Thank you for the requested information. During initial review of the amended Final Short Plat survey, CDS notes substantial changes taking place to lot lines and acreage associated with three of the four parcels. CDS previously agreed to allow minor changes to the lot lines in order to meet the 50' well setbacks. Substantial changes as proposed would require an amendment to the Approved Preliminary Short Plat.

Subject: SPF-21-00002 Zipperer - Comments and RFI Compliance

**ZIPPERER SHORT PLAT, SP-20-00005
 SPF-21-00002**

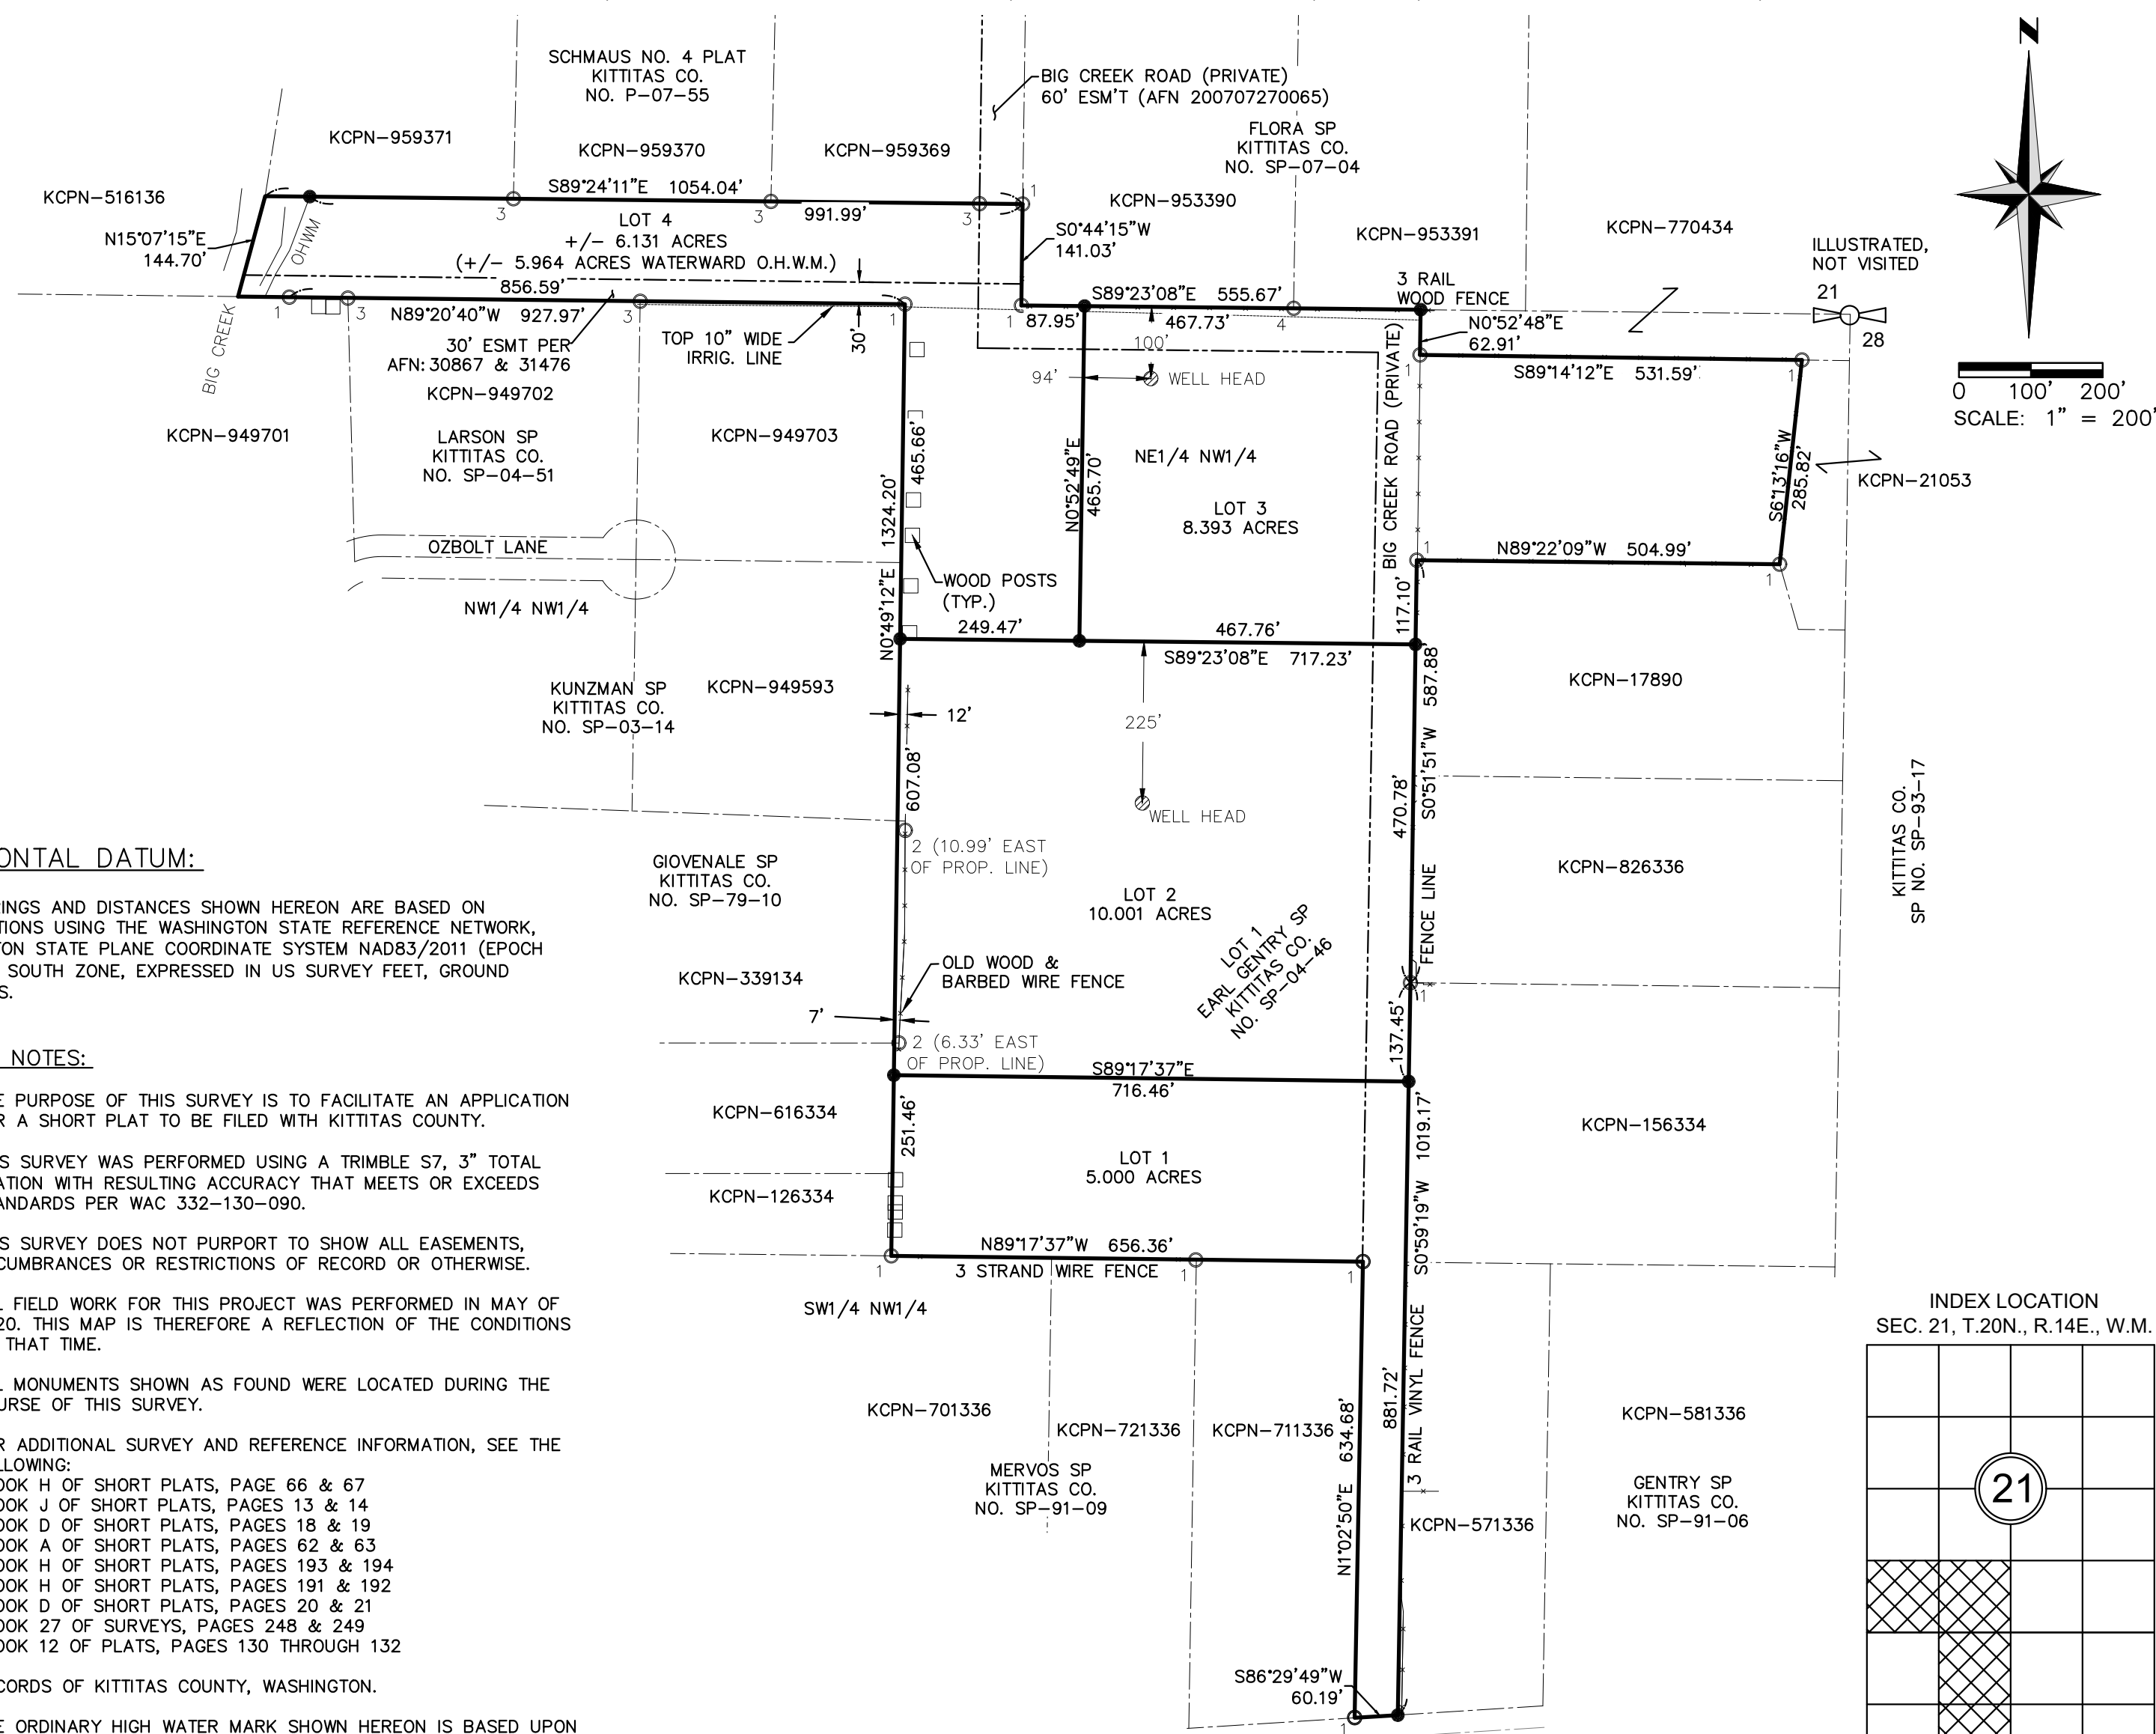
Please also note, the proposed Lot 2 North boundary line is the only interior boundary requested to be revised by Public Health. By moving that lot line further north, it automatically shortens the dividing line between Lots 3 and 4 - nothing can be done to prevent that while meeting the Public Health condition/requirement. Public Health is requiring that line to be moved further north and nowhere in the preliminary conditions of approval does it state that line can *only* be moved by 50’. In fact, CDS omitted this Public Health condition of approval from the Finding of Fact, Decision and Conditions of Approval altogether (attached for your reference). This condition was only cited by CDS in a letter dated July 1, 2021 with the Subject: Zipperer Short Plat Final (SPF-21-00002) – Staff Review and Request for Additional Information after the Final Short Plat Application was submitted (attached for your reference).

The Zipperer’s are proposing to move the exact lot line that Public Health is requiring them to move and all codes, standards, requirements, and conditions are still being met with this MINOR adjustment to the North interior boundary line of proposed Lot 2. Attached is a map of the preliminary short plat layout showing the North interior boundary line of proposed Lot 2 too close to the well head AND a map of the final short plat layout with the revised North interior boundary line of proposed Lot 2 meeting the condition as set forth by Public Health. We do not agree that this required interior lot line revision constitutes a re-application to amend the short plat as it is a condition that needs to be met for a short plat currently under review.

CDS is requesting an updated site map meeting the previously approved preliminary short plat with the acceptance of a few lot lines needing adjustment to meet the 50' minimum well setback or the applicant could choose to move forward with an amendment.

In subsequent conversation with the Planning Official, Jeremy Johnston, CDS staff agrees that although the lot sizes are changing significantly, substantial conformance is met. We have requested final review from both Public Works and Public Health. Once we have received final approval from each department, we will request the final mylars and route for final signatures.
